OFFICIAL NOTIFICATION OF DECISION

Project# PR-2021-004967 Application# DHOWVR-2025-00013 SIDEWALK WAIVER MINOR_PLT-2025-00019 PRELIMINARY/FINAL PLAT

LEGAL DESCRIPTION: For all or a portion of: LOT 107-A-2-A & Tract 107 A-1-A-1, MRGCD Map 31 zoned R-A, located at 3815 PEDRONCELLI RD NW between RIO GRANDE BLVD AND ELFEGO RD NW containing approximately 1.2324 acre(s) (F-13)

PLAT OF LOTS 1, 2 AND 3  
LANDS OF JOE GRADY

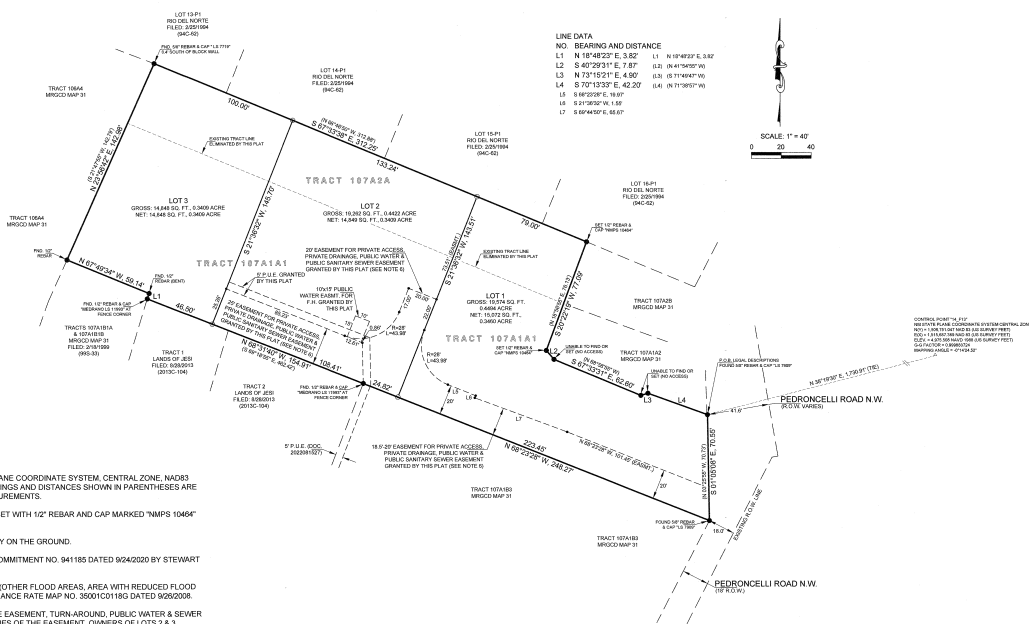
b. Provide dimensions of the alternate hammerhead.

- c. Clearly label each use for the proposed easement within proposed lot 1 such that each use is labeled public and/or private.
- d. Remove the proposed encroachment by narrowing the proposed easement where the existing garage is encroaching the proposed 20' easement for public water and public sanitary within proposed lot 1.

- e. Application number must be added to all documents.
- f. AGIS DXF file, with an approval email from AGIS submitted as proof.
- g. A note must be added to the Plat regarding the approval of this waiver from the DHO allowing no sidewalks, curb or gutters along Pedroncelli Rd NW.
